Mallard Pass Solar Farm

**Responses to Interested
Parties' Deadline 2 Submissions
- Climate Change**

EN010127/APP/9.21

Applicant's Response to Interested Parties' Deadline 2 Submissions on Climate Change

Plate 13-1 Proposed Development CO₂ Reductions

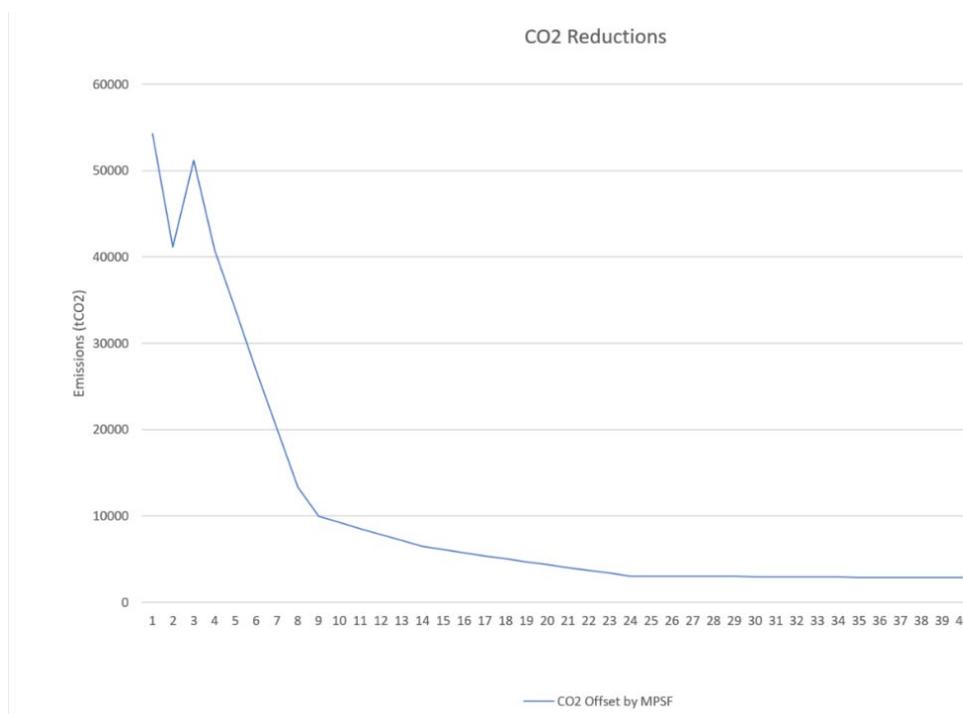
Parties Raised	Sub-Theme	Issues Raised	Applicant's Response
REP2-127 REP2-178 REP2-237, REP2-116, REP2-114, REP2-169, REP2-128, REP2-126 REP2-090 REP2-145		Concerned that the total actual lifetime CO2 reduction from the grid for the project is lower than the lifetime CO2 of the facility.	<p>Paragraph 13.4.14 of Chapter 13 refers to the IPCC (2014) estimated full life-cycle emissions of CO2 which for utility scale solar photovoltaic cells estimates an emission intensity of 48 kgCO2eq/MWh (based on the median value from a range between 18 and 180 kgCO2eq/MWh). The life cycle emissions for Solar PV within the IPCC report consider infrastructure and supply chain emissions for operation and decommissioning / disposal processes. The median figure of 48kgCO2eq/MWh is considered a conservative figure, i.e. it overestimates the likely carbon costs of the Proposed Development. This is demonstrated in reference Longfield and El Romero Solar projects which were assessed as having a lifecycle carbon emissions intensity of 38.3 gCO2e / kWh and 29.2 gCO2e / kWh respectively. These are both comparable in scale to the Proposed Development and include international transportation of PV arrays. The 48kgCO2eq/MWh value has also been applied over 40 years, rather than the 25 year period assumed in the IPCC report.</p> <p>Based on these conservative assumptions outlined above, paragraph 13.4.18 of Chapter 13 of the ES concludes that the Proposed Development delivers a net carbon benefit vs. total lifetime carbon cost (i.e. carbon neutrality) after approximately 10.5 years of operation and all savings beyond that would be a net benefit of the Proposed Development to reducing climate change, relative to the baseline, i.e. the Proposed Development will exceed a carbon neutrality position.</p>

<p>REP2-090, REP2-150, REP2-200</p>	<p>Key figures</p>	<p>The key figures for the Proposed Development have been overstated. Revised calculations are provided in Figure 6 of MPAG's Written Representation.</p> <p>According to MPAG, the realistic best-case headline figures for the Proposed Development are:</p> <ul style="list-style-type: none"> - The facility is likely to produce 253MWh, not 350MWh. This would be enough electricity for 67,000 homes (or 0.88% of the UK's electricity demand). - It is expected to start to benefit the planet from a CO2-reduction perspective in 18.2 years. 	<p>Chapter 13 Climate Change of the Environmental Statement (ES) [APP-043] presents the approach and findings of the assessment of potential climate change effects associated with the Proposed Development. Paragraphs 13.4.9 – 13.4.18 set out the assessment of Green House Gas (GHG) emissions and carbon savings.</p> <p>Assumptions</p> <p>Paragraphs 13.4.11-13.4.13 describe the processes which involve CO2 emissions for construction, operation and decommissioning phases of the Proposed Development.</p> <p>Paragraph 13.4.14 refers to the IPCC (2014) estimated full life-cycle emissions of CO2 which for utility scale solar photovoltaic cells estimates an emission intensity of 48 kgCO2eq/MWh (based on the median value from a range between 18 and 180 kgCO2eq/MWh). The life cycle emissions for Solar PV within the IPCC report consider</p>

Parties Raised	Sub-Theme	Issues Raised	Applicant's Response
		<p>savings would be 1.25m teCO₂. Significantly lower the 1.9m teCO₂ claimed by the Applicant. A higher, more realistic lifecycle emission for MPSF of 72kgCO₂eq/MWh would reduce the lifecycle saving 0.96m teCO₂</p>	<p>net benefit of the Proposed Development to reducing climate change, relative to the baseline.</p> <ul style="list-style-type: none"> • Over 40 years, the saving is estimated at approximately 1.9 million tonnes of CO₂ <p>The Applicant has supplied at Appendix G to this response a GHG Calculations Table which sets out the assumptions referred to in Chapter 13 of the ES, and presents the following conclusions in direct response to MPAGs Written Representation:</p> <ul style="list-style-type: none"> • The Proposed Development would have an indicative installed capacity of 350MW • Total carbon cost of the Proposed Development including construction, operation (negligible) and decommissioning = 672,000 Tonnes (Te) CO₂ • Annual amortised carbon cost = 16,800 (te) of CO₂/Year • The Proposed Development delivers a gross carbon benefit vs. current grid carbon intensity for every year of operation • The Proposed Development delivers a net carbon benefit vs. amortised lifetime carbon cost for every year of operation • The Proposed Development delivers a net carbon benefit vs. total lifetime carbon cost from Year 10.5 onwards • The Proposed Development delivers a total net carbon benefit of 1.6 million tonnes of CO₂ over a 40 year period <p>Capacity / Solar Load factor</p> <p>In preparation of this response, the Applicant has noted a typographical error in the assumption related to solar load factor. This is stated as 10% in paragraph 13.5.10. The</p>

REP2-090	Displacement of embodied CO2	Due to grid decarbonisation, the embodied CO2 will not be displaced during the lifetime of the Proposed Development. If the facility were not built, and the grid decarbonised through other forms of low carbon production, there would be less CO2 released into the atmosphere.	Paragraph 13.4.17 of Chapter 13 of the ES recognises that Grid decarbonisation will reduce the average emissions of CO2 and therefore the total reduction of savings above associated with the Proposed Development correspondingly. However, to achieve decarbonisation of the grid, energy sources such as the Proposed Development are required to meet Government targets relating to GHG emissions. Therefore, whilst the decarbonisation of the grid would reduce the savings associated with the Proposed Development, infrastructure such as the Proposed Development is a pre-requisite to such decarbonisation.

Parties Raised	Sub-Theme	Issues Raised	Applicant's Response
		<ul style="list-style-type: none"> - It should assist decarbonisation of the UK grid by 46,056 tonnes CO₂ annually (or a reduction 0.013% of the UK annual Grid CO₂). - It should produce a total reduction during its lifetime of 0.96m tonnes CO₂. <p>The Proposed Development is anticipated to have an installed capacity of 350 MWp, a capacity factor estimated at 10 % and would be available to operate for 8,760 hours per year. This means that the Proposed Development is anticipated to generate approximately 350,000 MWh of renewable electricity per year. I have some difficulty understanding this claim as there are only 8760 hours a year, implying that the solar farm will be generating electricity into the National Grid 24 hrs a day, 365 days a year. Is this really true?</p> <p>The Applicant has made an arithmetical mistake in calculating the output of the development. In ES Volume 1 Chapter 13: Climate Change, the Applicant correctly states that the calculation for the output is 350MW capacity x 8760 hours/year x 10% plant load factor. The Applicant calculates the result as 350,000MWh.</p> <p>The correct number is 306,600MWh. The corrected, lower output has a direct impact on the value of the development in meeting the net zero commitments of the Government. Taking the value for lifecycle emissions used by the Applicant of 48kgCO₂eq/MWh and the corrected output of MPSF, including panel degradation, the</p>	<p>infrastructure and supply chain emissions for operation and decommissioning / disposal processes. The median figure of 48kgCO₂eq/MWh is considered a conservative figure, i.e. it overestimates the likely carbon costs of the Proposed Development. This is demonstrated in reference Longfield and El Romero Solar projects which were assessed as having a lifecycle carbon emissions intensity of 38.3 gCO₂e / kWh and 29.2 gCO₂e / kWh respectively. These are both comparable in scale to the Proposed Development and include international transportation of PV arrays. The 48kgCO₂eq/MWh value has also been applied over 40 years, rather than the 25 year period assumed in the IPCC report.</p> <p>Paragraph 13.4.15 refers to the Digest of UK Energy Statistics (DUKES) which indicates the average electrical output being generated at the national grid had a carbon intensity in 2020 of 182gCO₂e/kWh. It is noted that this represents the operational carbon intensity of the mix of sources of electricity on the grid, it does not account for embodied carbon of the construction of those electricity generating stations.</p> <p>Paragraph 13.4.16 confirms the panel degradation assumptions include in the assessment, which states that power degradation for the first year will be no more than 2% followed by no more than 0.45 % in subsequent years.</p> <p>The above confirms that the assumptions underpinning the GHG calculations for the proposed development are conservative.</p> <p>Conclusions</p> <p>Paragraph 13.4.18 concludes that:</p> <ul style="list-style-type: none"> • The CO₂ emissions of the Proposed Development would therefore be displaced within approximately 10.5 years, and all savings beyond that would be a

Parties Raised	Sub-Theme	Issues Raised	Applicant's Response
			<p>corrected value should be 11.4% which has been used to derive the output calculation. This is clarified in the assumption set out in the GHG Calculations Table (Appendix GX).</p> <p>This does not result in any change to the assessment outcomes of Chapter 13 of the ES. All calculations within the chapter were based on the 11.4% value, which is clarified in the GHG Calculation Table.</p> <p>Solar load factor can vary between technologies (i.e. Fixed South Facing or Single Axis Trackers), different inverter configurations and meteorological and geographically. 11.4% represents a conservative assumption for the solar load factor at Mallard Pass based on a range of factors, including actual historical average hours of sunlight per year specifically registered at the locality of the Proposed Development.. The solar capacity factor includes allowances for losses in the equipment and connection to provide the produced energy of the PV System.</p> <p>It is also noted that the approximate 1.9 million figure did not account for panel degradation. The corrected figure is presented in the GHG Calculations Table as 1.6 million tonnes of CO2 over a 40 year period.</p> <p>Finally, it is noted that even if utilising the figures presented in the Figure 6 of MPAG's Written Representation, the Proposed Development would still generate significant levels of renewable electricity, recover its total lifetime carbon cost well within the operational period of the development and provide a significant overall carbon reduction over its operational lifetime.</p>
